RESPONSE TO SUBMISSIONS

SSD-24452965 - Eels Centre
of Excellence and Community
Sports Hub, Kellyville

PARRAMATTA EELS

2 August 2022

A14

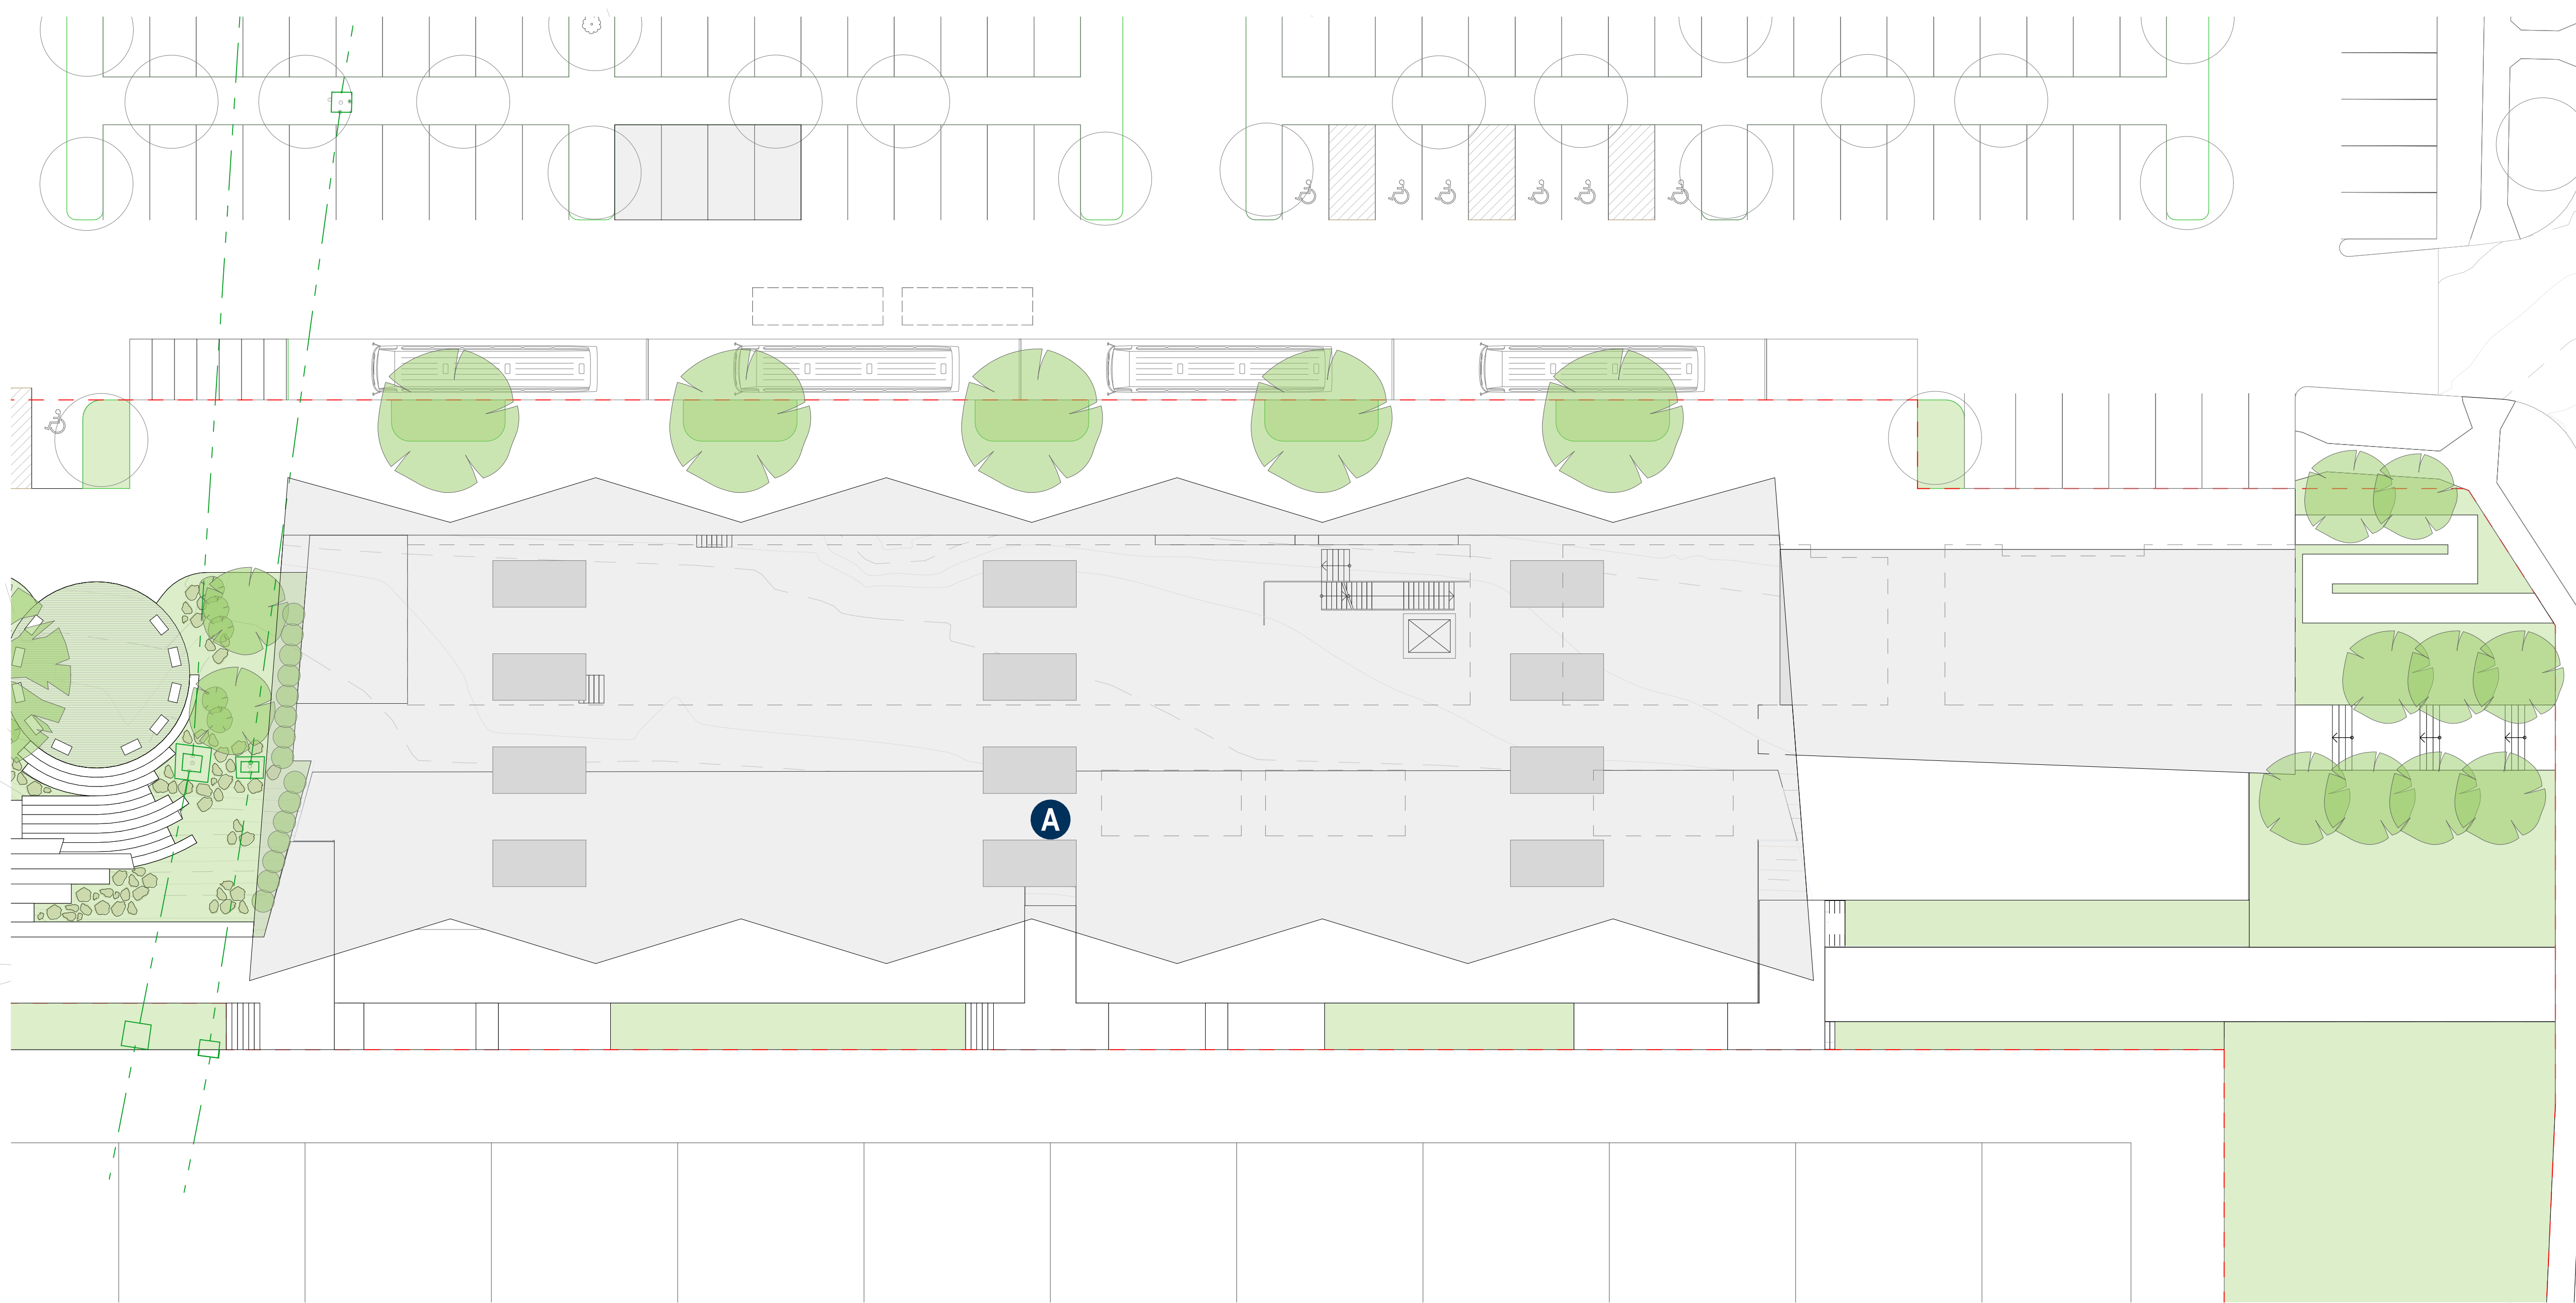
<p>Public Benefits</p> <p>Consider options to provide additional public benefits such as the provision of a children's play area into the design of the development.</p>	<p>Hills Shire Council have provided the approved Kellyville Park Master Plan from 2019 with the "statement of intent" which references the playground in the south eastern corner of the site. This is to be undertaken by Hills Shire Council.</p> <p>The scope of works proposed is limited ot that of the COE and Community Facility buildings, and does not extend beyond into the broader site. This has been made clear in the EIS and supporting doucmentation, and was discussed at length during the pre-lodgemrnt consultantion with the DRP and DPE.</p>	<p>Appendix M – Kellyville Masterplan</p>
<p>Public Benefits</p> <p>Confirm the nature of the tenancy in the community facility (Item 17 on plan number</p>	<p>The proposed tenant is unknown at this time however will be consistent with the permissable uses. It is considered ancillary and subordinate to the primary use of the site being a recreation facility (major). Permissible land uses include:</p> <p><i>Aquaculture; Boat launching ramps; Building identification signs; Business identification signs; Car parks; Centre-based child care facilities; Community facilities; Emergency</i></p>	<p>N/A</p>

Summary of Issue Raised	Response	Supporting Document
A14, titled "GA Community Facility Upper Plan" dated 7/04/2022	<p><i>services facilities; Environmental facilities; Information and education facilities; Jetties; Kiosks; Markets; Recreation areas; Recreation facilities (indoor); Recreation facilities (major); Recreation facilities (outdoor); Respite day care centres; Restaurants or cafes; Roads; Take away food and drink premises; Water recreation structures</i></p> <p>The likely land use will be "information or educational facilities" and will be subject to a separate application. As mentioned, it is considered ancillary and subordinate to the primary use of the site.</p>	
<p>Hours of Operation</p> <p>Confirm days and hours of operation for the Centre of Excellence and Community Facility as the hours of operation vary between documents.</p>	<p>The hours of operation for the proposed development are:</p> <p>COE:</p> <ul style="list-style-type: none"> Monday-Friday 5.00am - 12.00am Weekends / public holidays are 6.00am - 12.00am <p>CF:</p> <ul style="list-style-type: none"> Monday-Friday 5.00am - 12.00am Weekends / public holidays are 6.00am - 12.00am 	N/A

# SUN & SHADING STUDY

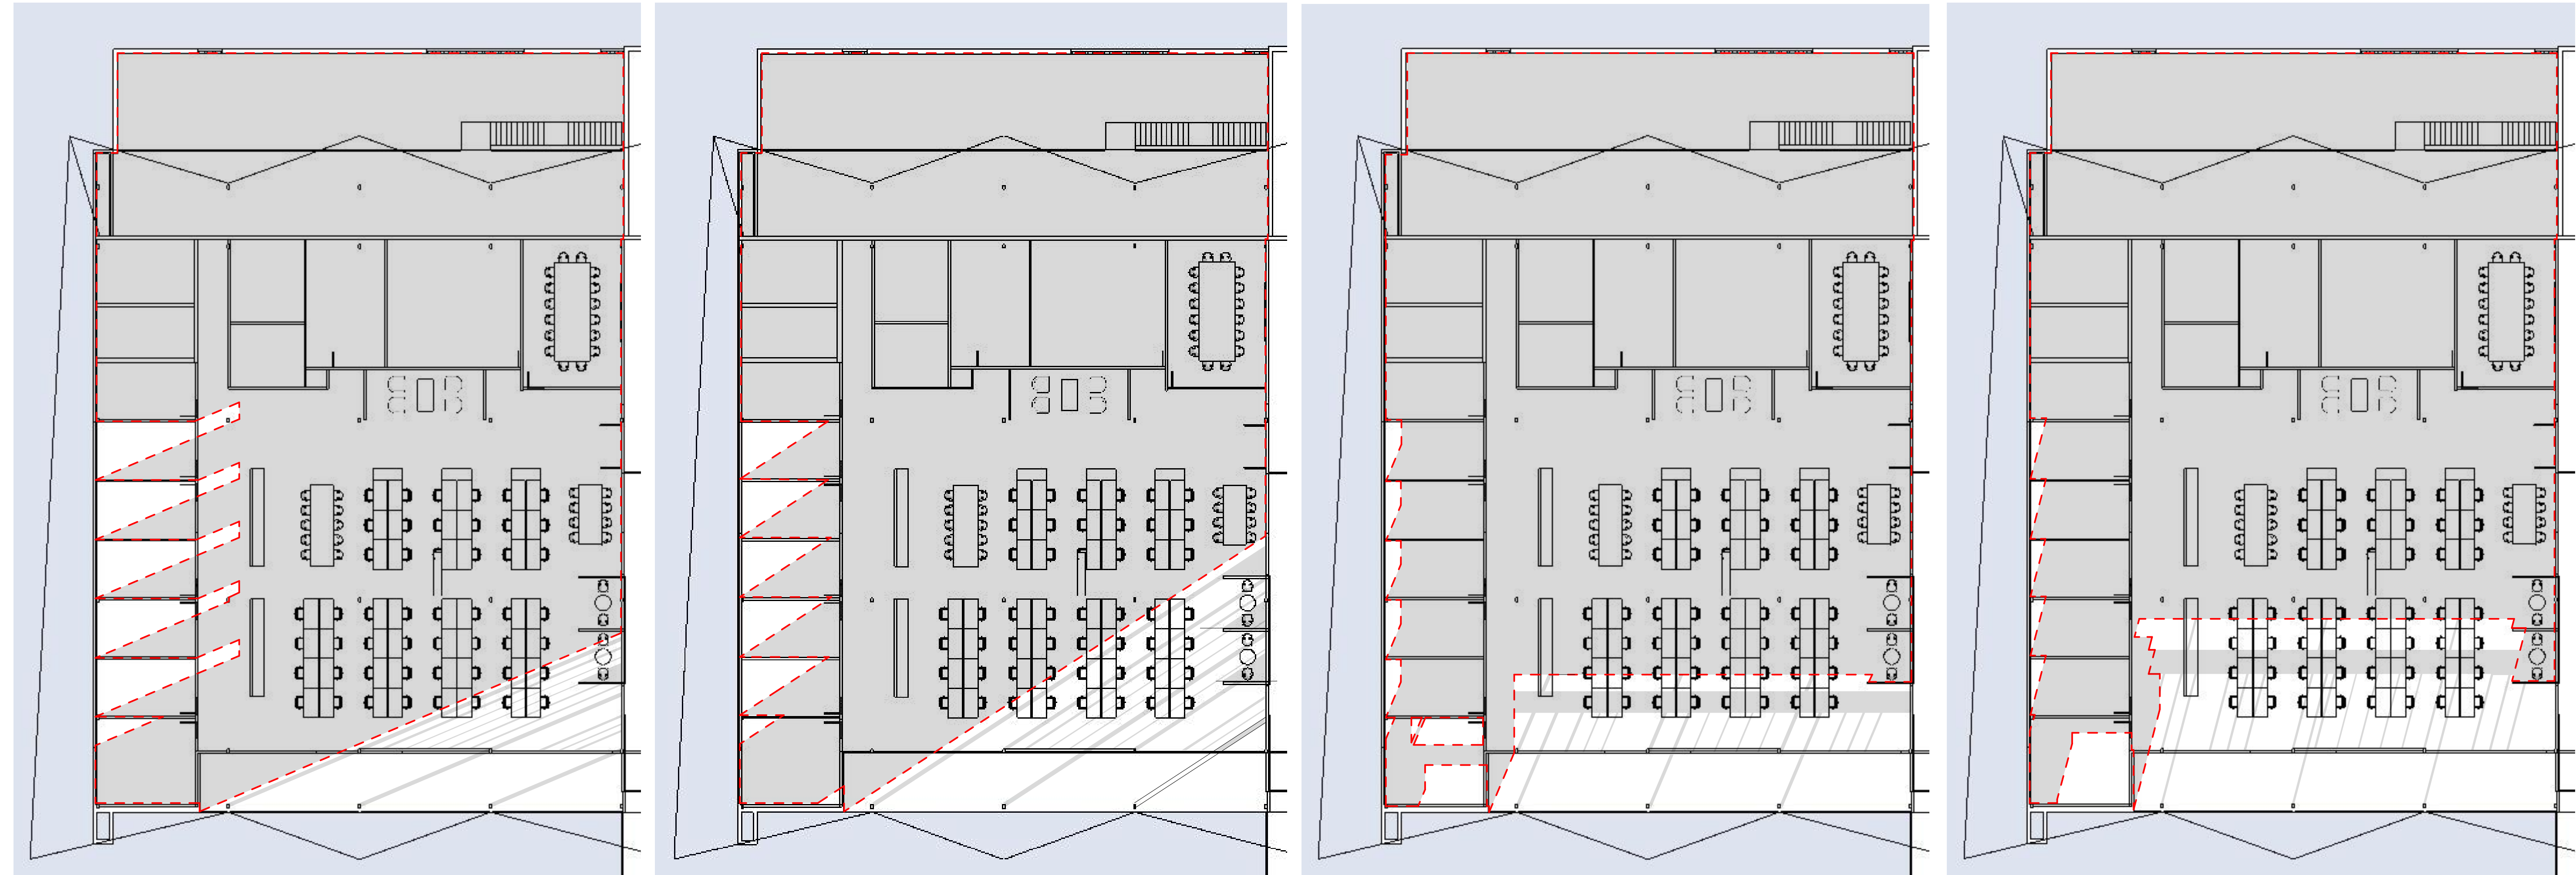
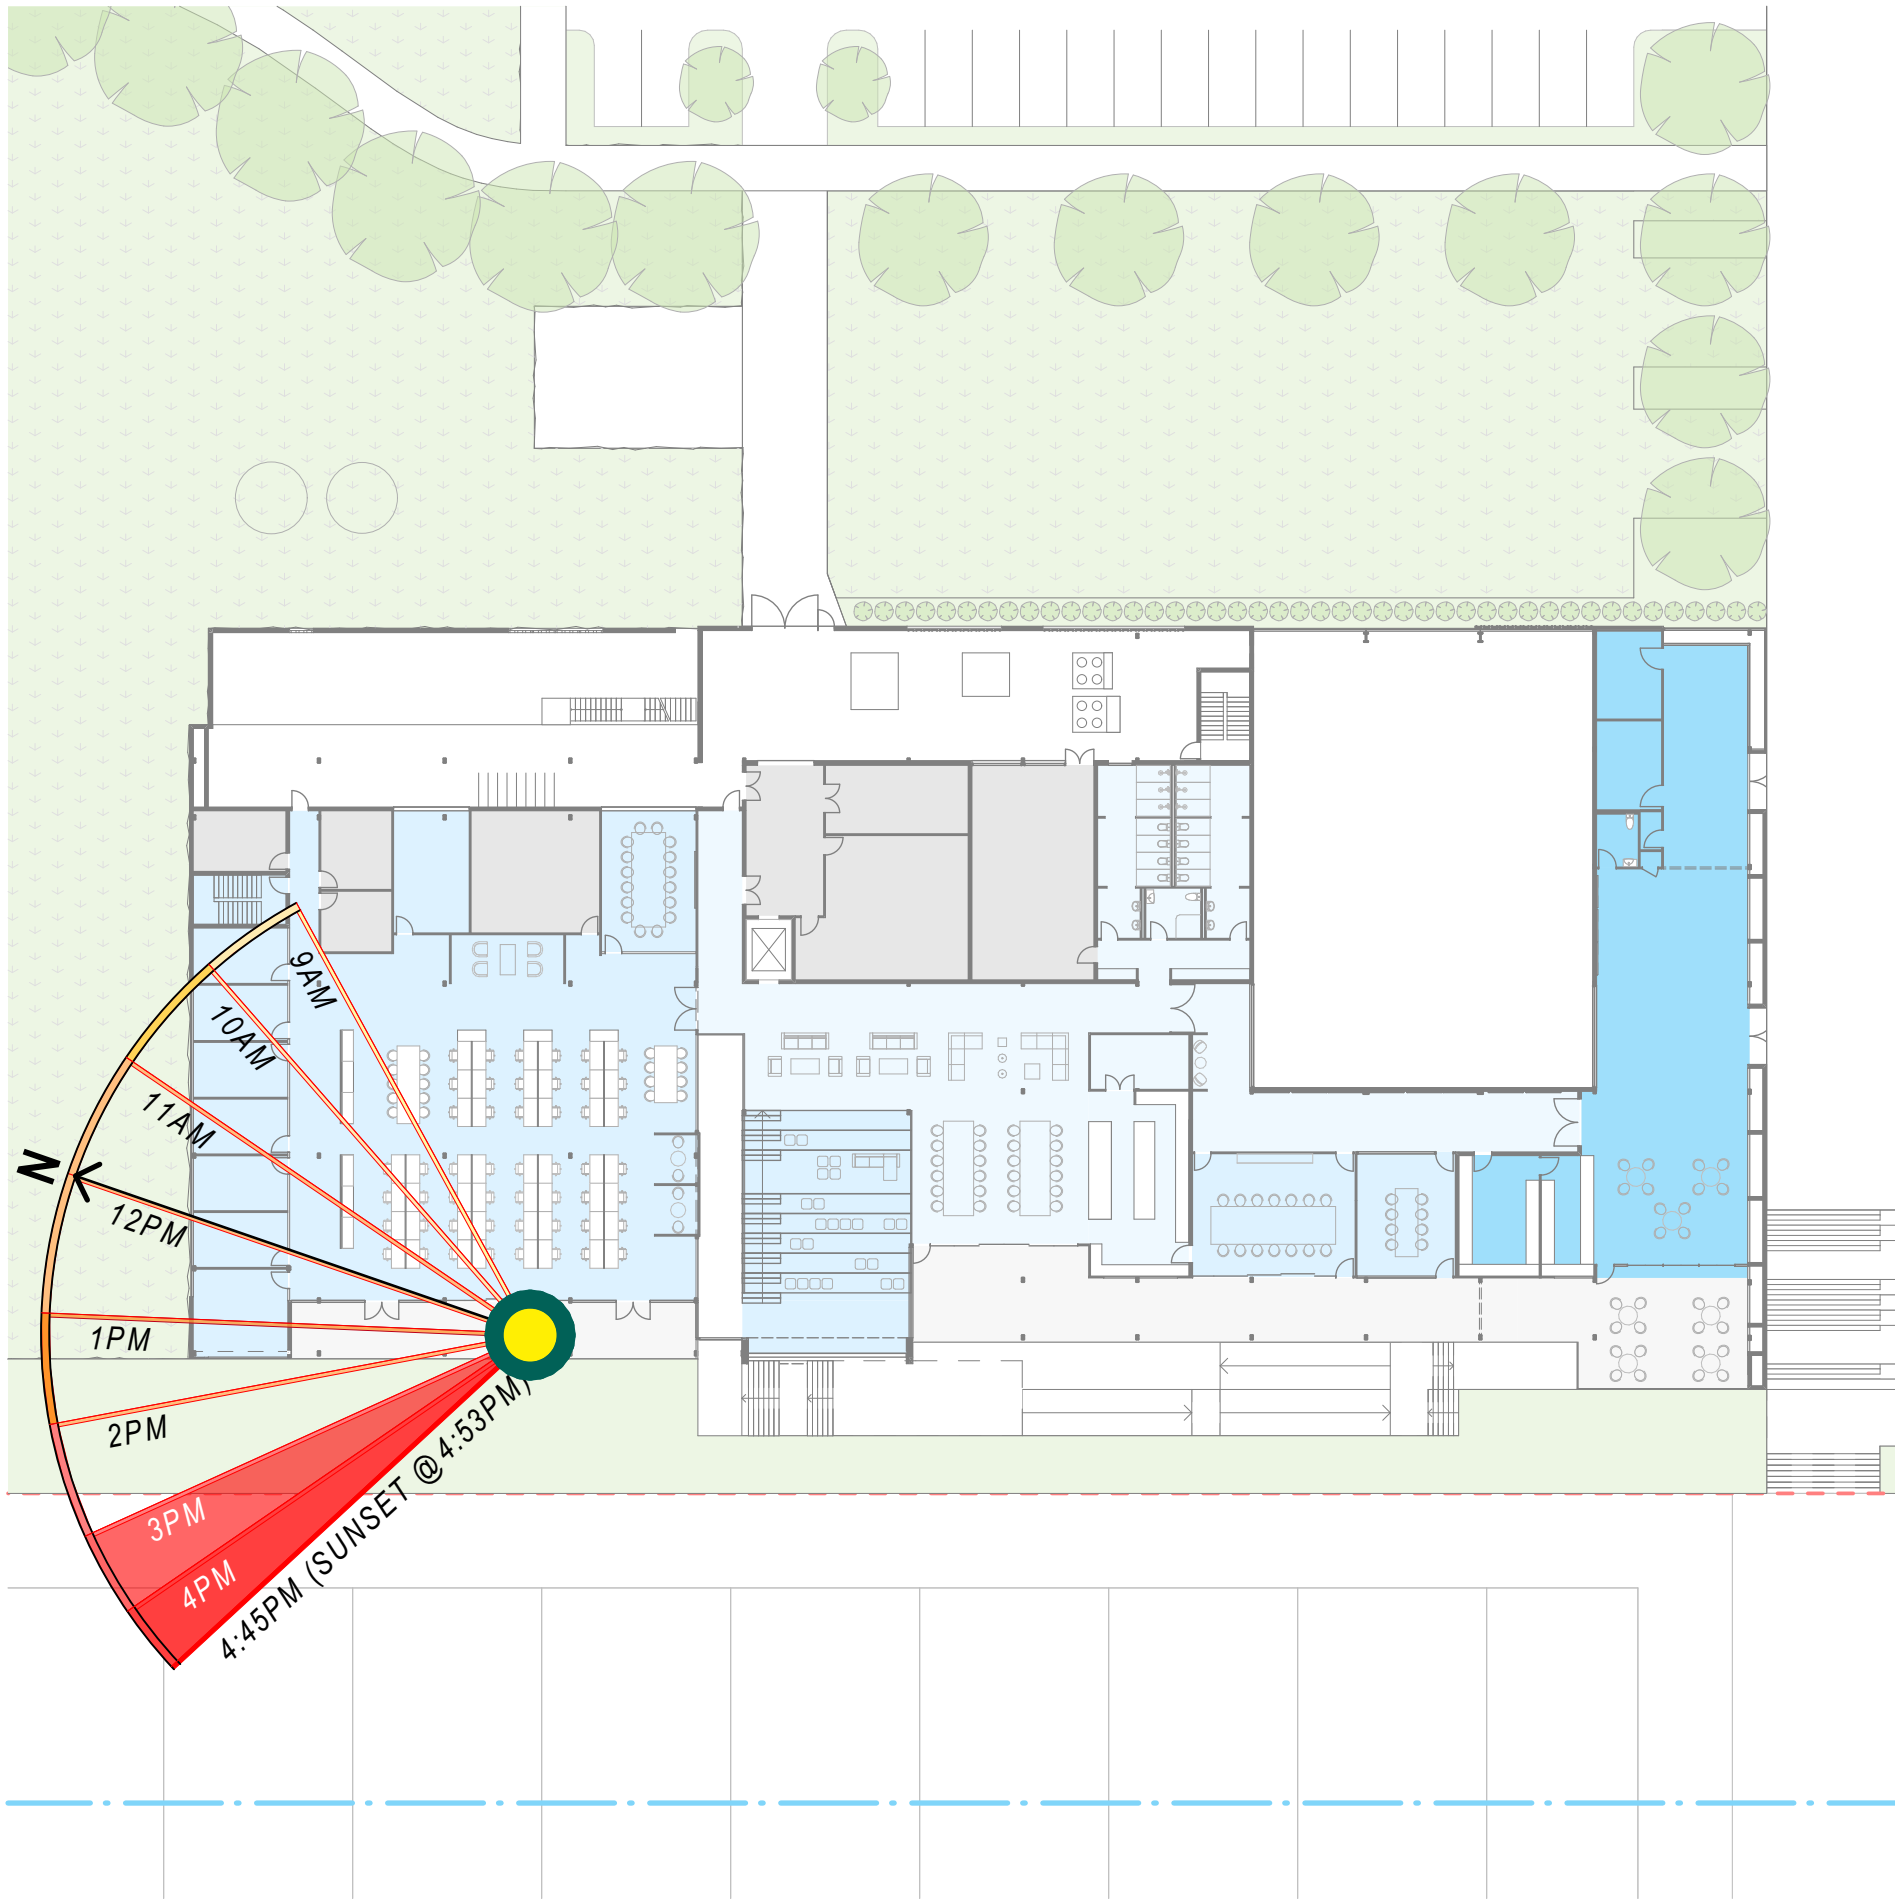
<p>Screening</p> <p>Provide external sun shading to minimise mid-summer sun during working hours. This can be designed so as not to interfere with sightlines to the playing field.</p>	<p>HB Arch have undertaken further design development and assessment of the COE's thermal envelope including the glass design of the west facade. This work supports the design balance as reflected in the proposed COE by drawing natural daylight inside, achieving a high level of visual connection between the inside and outside functional areas (which includes the training fields) and controlling any detrimental impact of direct sunlight late afternoon in the summer months.</p> <p>Erbas Sustain (project Sustainability Consultants) have considered the need for western sun-shading and advised, the following:</p>	<p>Architects Design Statement Revision E Section 6.4</p>

Summary of Issue Raised	Response	Supporting Document
	<p><i>1. External shading device would typically be used to reduce solar gains. Glare from low western sun is best managed with internal blinds by individual building users.</i></p> <p><i>2. In the response to RFI, we are considering the following statement 'We are proposing the glazing system with best selectivity (VLT/SHGC)>2 to maximise daylight and minimise solar gains'.</i></p> <p><i>3. We recommend Viridian Performatech PH(60) + Super Clear (Double glazed 6-12-6mm) with a VLT70% and SHGC0.33, resulting a Selectivity Ratio of 2.12, which will reduce the solar gains by more than 30%, whilst providing necessary Thermal Comfort and maintaining a relatively high daylight value for a solar control glass.</i></p> <p>Selectivity is the balance or ratio between VLT (visible light transmission) and SHGC (solar heat gain co-efficient). Values higher than 2.0 are considered to be best practice and are achieved with relatively clear glass DG units that achieve high performing solar and thermal control.</p> <p>The JV3 model confirms the proposed internal environment has a high level of Thermal Comfort, Human comfort, and Daylight (reducing the demand for artificial lighting) whilst minimising Energy demand (for heating / cooling) to be at least 10% lower than the Building Code Deemed to Satisfy values.</p> <p>Providing simple but effective internal blinds is a fundamental of 'Healthy user-friendly building design' as recognised by Greenstar, where individuals have the choice to lower and adjust internal blinds to adjust and suit their own preferences for the work environment.</p> <p>The building form (roof overhang and facade articulation) does assist in screening the direct sun into the COE work spaces.</p>

Summary of Issue Raised	Response	Supporting Document
	<p>To further screen direct sun (Mid-summer 3pm-5pm) would require sun-shading to be square (perpendicular) to the low sun angle. This would result in a significant reduction to the visual connection between the indoor and outdoor functional spaces, as well as reduced in-direct ambient daylight from early morning until later in the afternoon when the west sun reaches the west face.</p> <p>Operable sun-shading is not supported by the design team as the complexity of an operable system is considered a maintenance risk with the poor durability of such systems often leading to operable systems breaking down and becoming in-operable within a short lifespan.</p>	
<p>Trees</p> <p>Tree number T17 (Willow Gum) is a significant tree and options should be considered to preserve and incorporate the tree into the design of the development.</p>	<p>As outlined on page 17 of the Designing with Country report , a Totem will utilise the timber from the existing tree (T17).</p> <p>Furthermore, as outlined in the Arborist Statement prepared by Earthscape, the subject tree stands more or less centrally within the site and is proposed to be removed to accommodate the new grandstand. There are no feasible options that can be recommended that would permit this tree to be retained unless substantial redesign of the site were to occur. The Tree Protection Zone (TPZ) calculated in accordance with AS4970:2009 is 12.8 metres radius, which is a significant constraint to the development of the site given the location of the tree.</p> <p>The subject tree is a solitary planted specimen of approximately 15 metres in height, 16 metres crown spread and 1 metre trunk diameter. It is agreed that the tree has substantial dimensions and makes a fair contribution to the amenity of the site. However, as noted in Sections 5.2 and 5.3 of the Arborist Report, the subject tree has no special ecological or heritage significance in the context of this site. The tree was assessed to be in fair health and condition, containing a number of wounds and broken branch stubs (some of up to 200mm in diameter) throughout the crown due to previous storm damage and a moderate wound and cavity on the lower trunk with decay evident. The tree was</p>	<p>Arborist Statement – Appendix F</p>
